**Cory Decarbonisation Project**

**Planning Inspectorate Reference: EN010128**

**SAVE CROSSNESS NATURE RESERVE**

**Deadline 6 Submission**

Figure 9 – Operational phase ProW diversions and ProW creations (repeat)

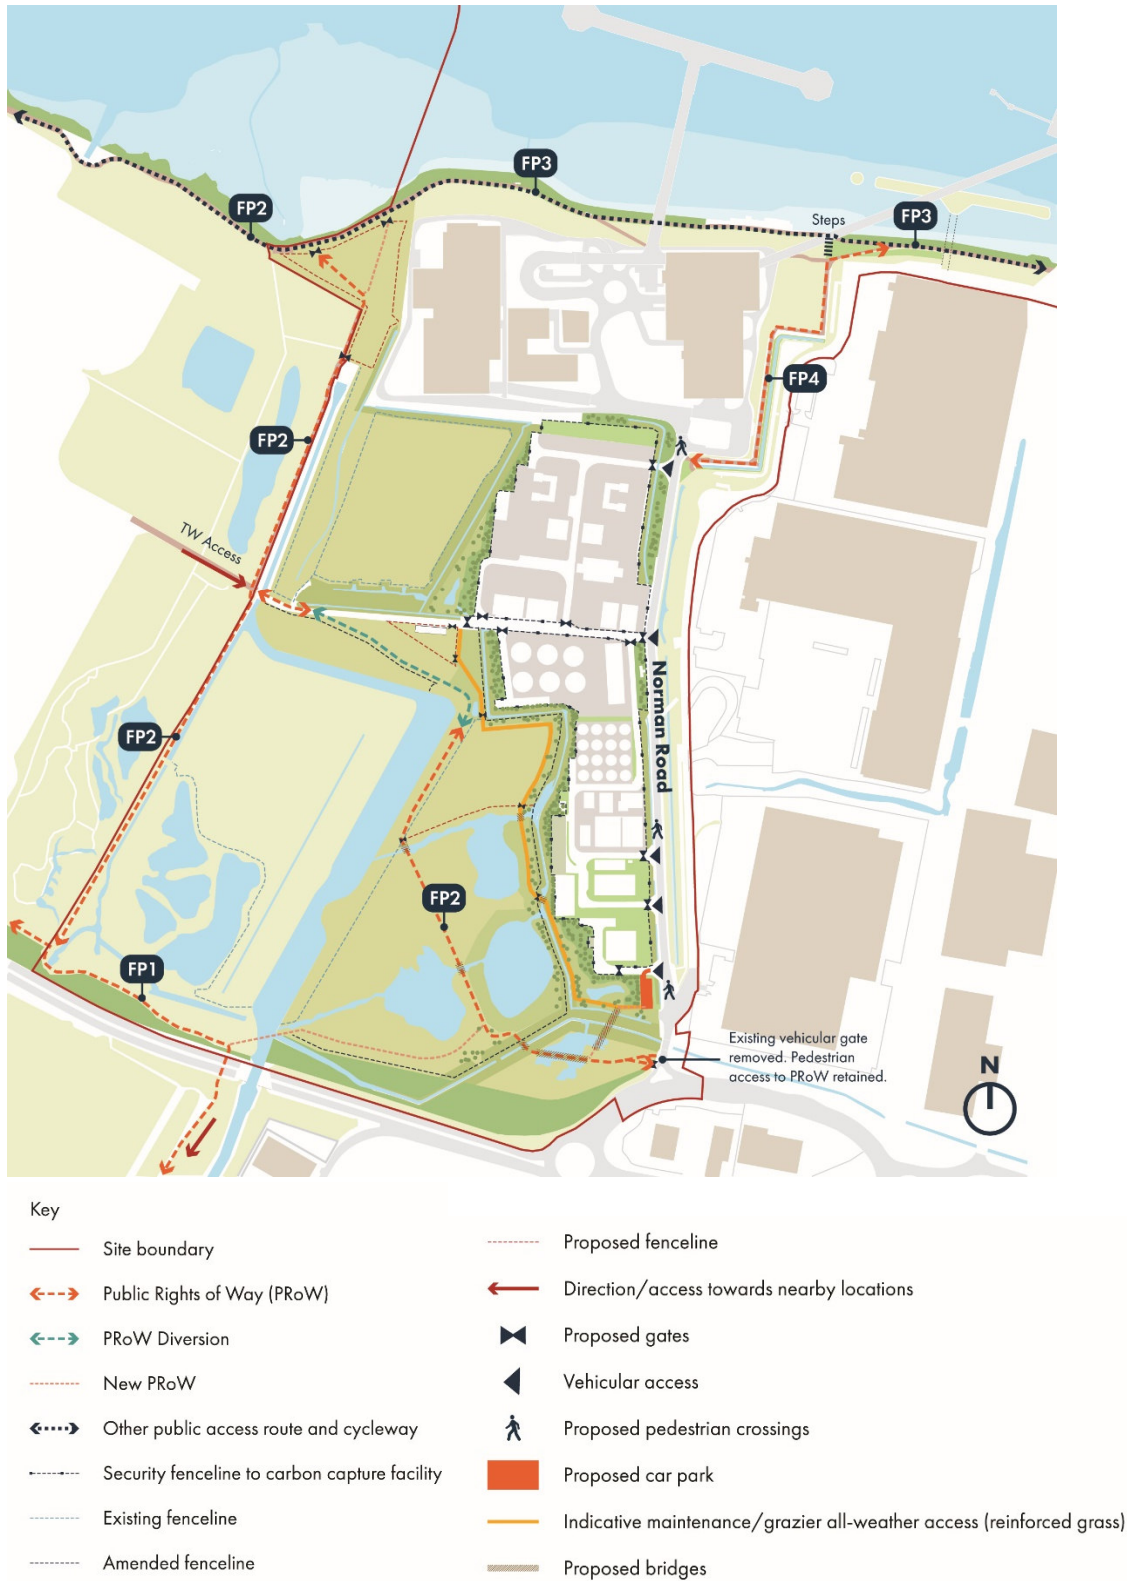
1. In the revised Outline LaBARDS, the Applicant proposes a new alternative access route for TWUL, EA, graziers and volunteers (including SCNR). The location of this route raises very serious concerns:

- a. This will result in a large further loss of habitat across Lagoon Field and Norman Road Field – noting the route requires a particularly long detour around the southern stretch of the Proposed Scheme;

- b. The area affected includes the area where SPI plants were identified by Dr Mark Spencer. Therefore, it is highly likely that this will result in a further direct loss of SPI;

- c. The route will need to be a wide road to accommodate two-way traffic, large vehicles for maintenance / emergency access, and a large turning circle. The amount of habitat loss will be significant – greater than Outline LaBARDS Figure 9 suggests;

- d. Beyond direct loss of habitat, the route will cause further fragmentation which will have a significant impact on animal species and SPIs;
  - e. The raised ground levels and built structures required will increase the likelihood of flooding on Norman Road Field, which is already prone to significant flooding (particularly in winter); and

- f. The route will require significant maintenance, requiring significant cost and site manager time.
2. None of these significant impacts has been assessed. No additional mitigation is proposed for this loss of habitat and broader ecological harm; therefore, this is a further failure to follow the mitigation hierarchy.
